MEMORANDUM

RE: Intrachat Hoang Residence
7929 East Mercer Way
Mercer Island, Washington
NGA File No. 1276521

This memorandum presents our responses to the geotechnical peer review performed by the City of Mercer Island regarding the proposed residence development located at **7929 East Mercer Way on Mercer Island, Washington.**

Slope Stability Analysis - Cross Section A-A' Seismic Conditions

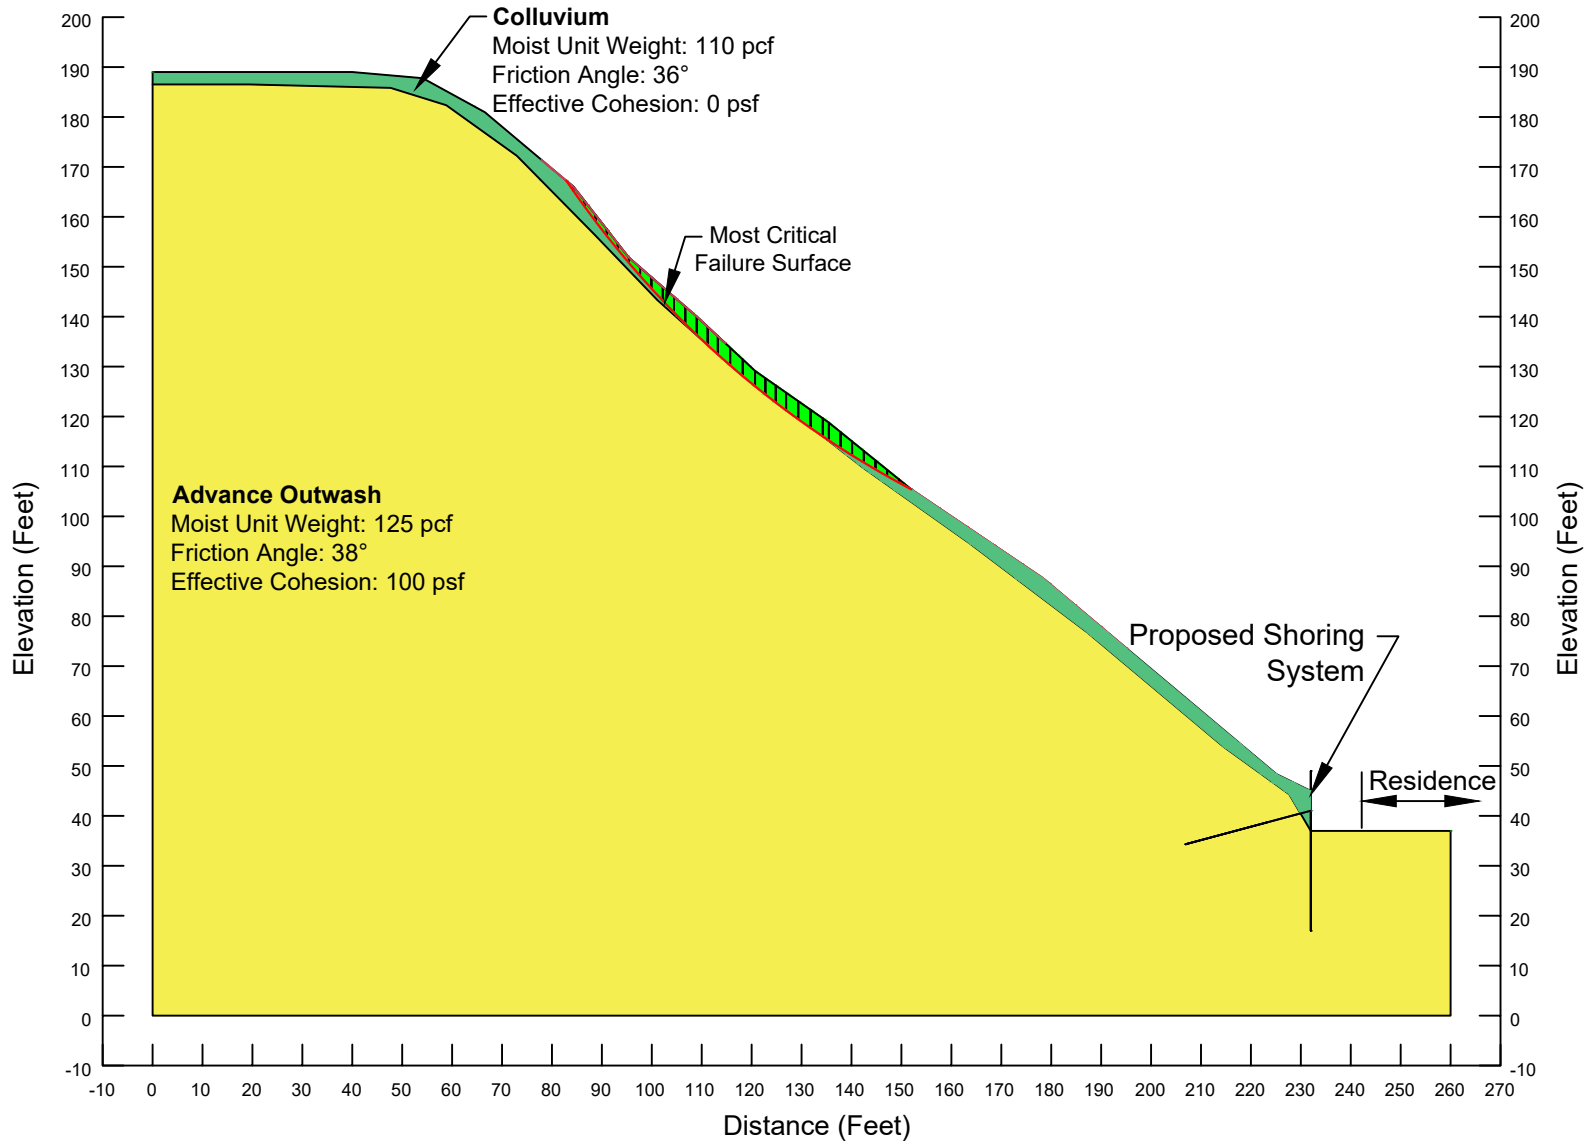
Comment 3: *The NGA response gives the basis of the pseudostatic coefficient, however, please review the calculations since the results do not agree with general discussion presented in NHI 11-032. For example, on NHI page 6-8, "Values of β less than 1.0 in Equation 6-3 and in Figure 6-3 would be typically associated with seismic conditions in the eastern United States, firm ground conditions, and lower acceleration levels, while values of β greater than 1.0 would be associated with the Western U.S., higher accelerations, and Site Class C or D site conditions." Beta value used by NGA is 0.734.*

NHI Figure 6-3 indicates that the scaling factor, alpha, should be at least 0.5 for a beta value of 1 and slope height of 100 feet. NGA indicates an alpha value of 0.367.

Please review and revise submitted calculations and revise stability analyses to reflect revised pseudostatic coefficient. Provide results in report addendum.

Response 3: The calculations were revised and attached to this document as Figure 3. Accordingly, the pseudostatic coefficient of horizontal ground motion selected for the slope stability analyses is 0.19g. A revised slope stability analysis was provided utilizing Slide2 by Rocscience and resulted in very similar results with respect to size and shape of slide and with a factor of safety for sliding of 0.995. The revised slope stability analysis is provided in Figure 1.

Intrachat Hoang Residence

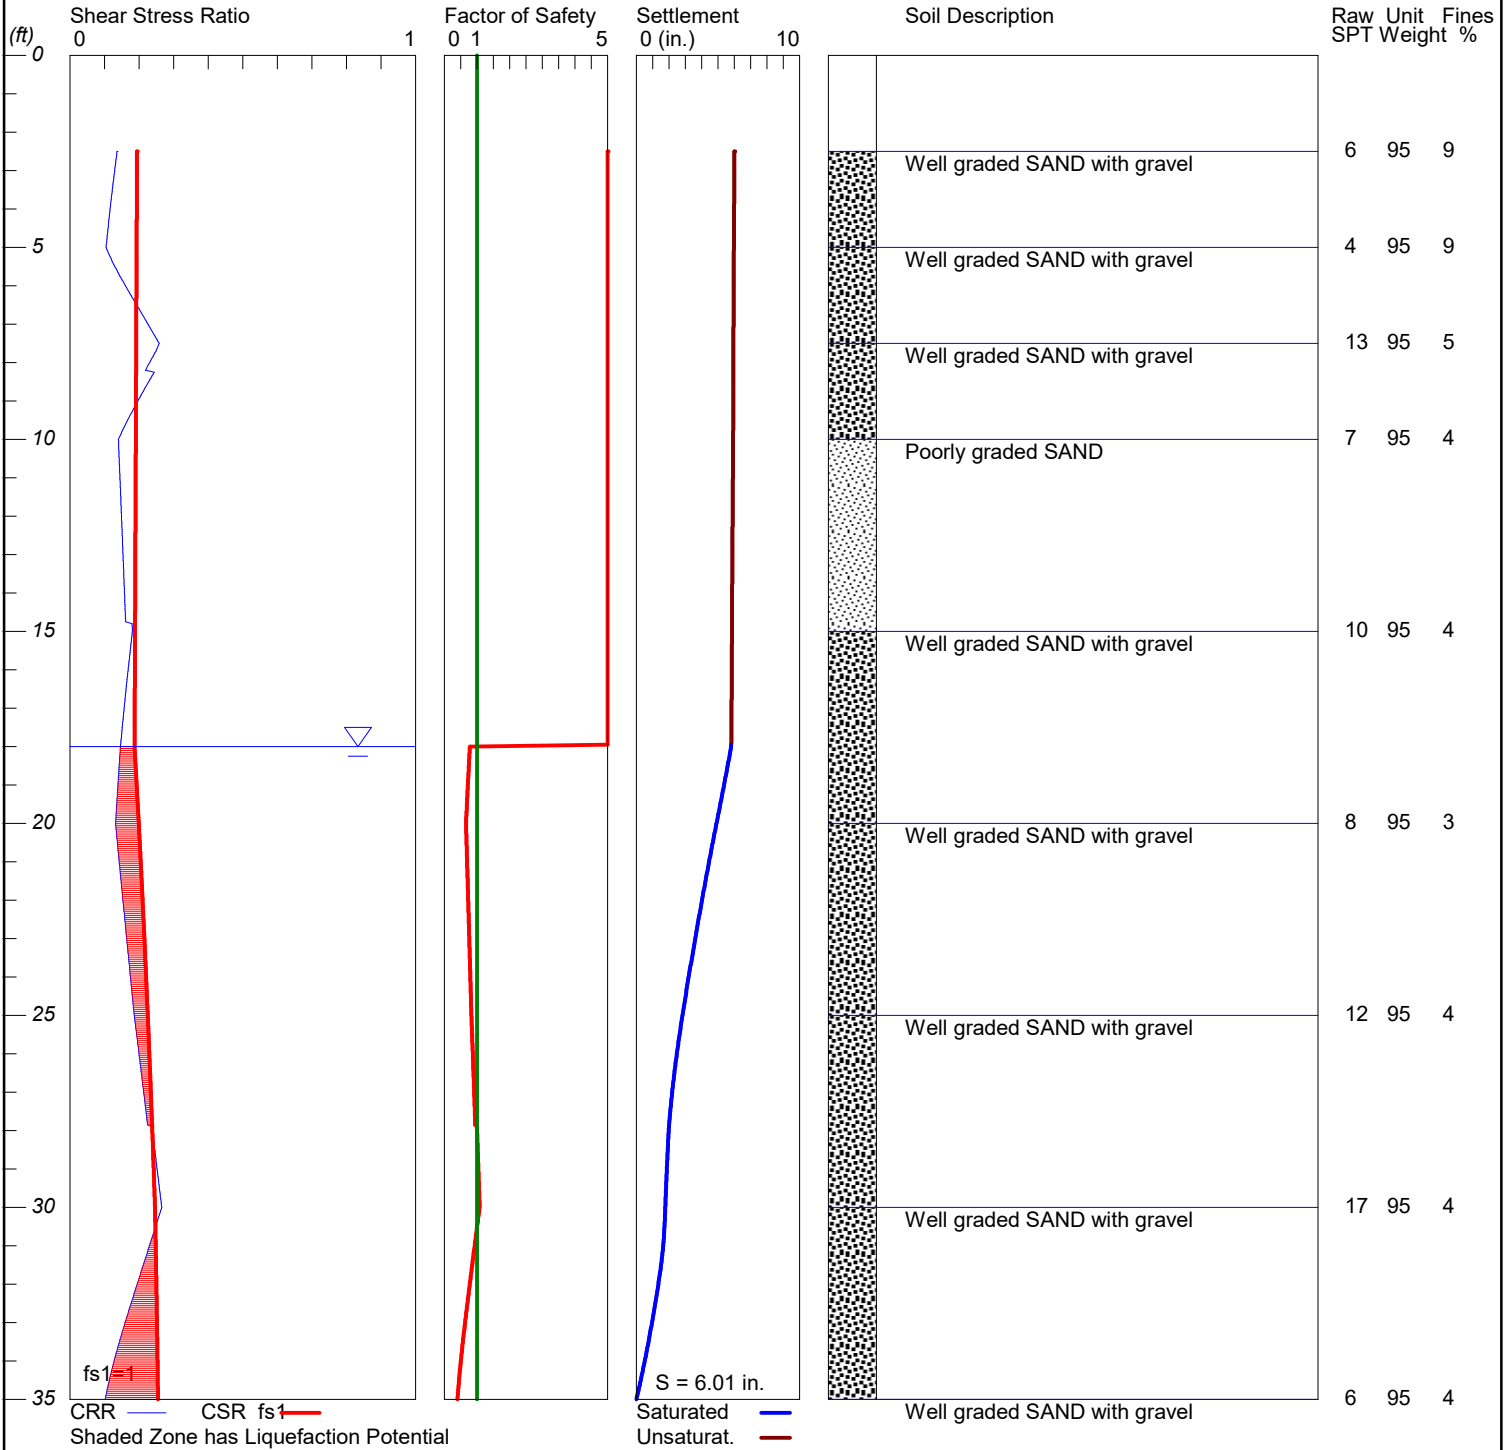
Comment 1: *On page 2 of NGA response provided in 01/11/24 memo, the following was noted: "An acceleration of 0.3g was utilized in the modeling and is reflective of a 50 percent reduction in the peak ground shaking, due to excess pore water pressure generation and subsequent soil stiffness softening."*

IBC and ASCE 7-22 indicate the use of MCE ground motion to evaluate liquefaction potential.

"The potential for liquefaction, seismically-induced permanent ground displacement, and soil strength loss evaluated for site peak ground acceleration, earthquake magnitude, and source characteristics consistent with the MCEG peak ground acceleration. Peak ground acceleration shall be determined based on either (1) a site-specific study taking into account soil amplification effects as specified in Section 11.4.7 or (2) the value of the MCEG peak ground acceleration parameter PGAM from the USGS Seismic Design Geodatabase for the applicable site class."

Please revise the liquefaction potential calculations and post-liquefaction settlement estimates to use MCE loading instead of the current 50% reduced value.

Response 1: The liquefaction analysis has been revised to include the maximum considered earthquake geometric mean value of 0.687g, as a site-specific seismic evaluation has not been performed for this site. The results indicated up to 11.36-inches of liquefaction induced settlement. The results of the analysis are attached to this document as Plate A-1.
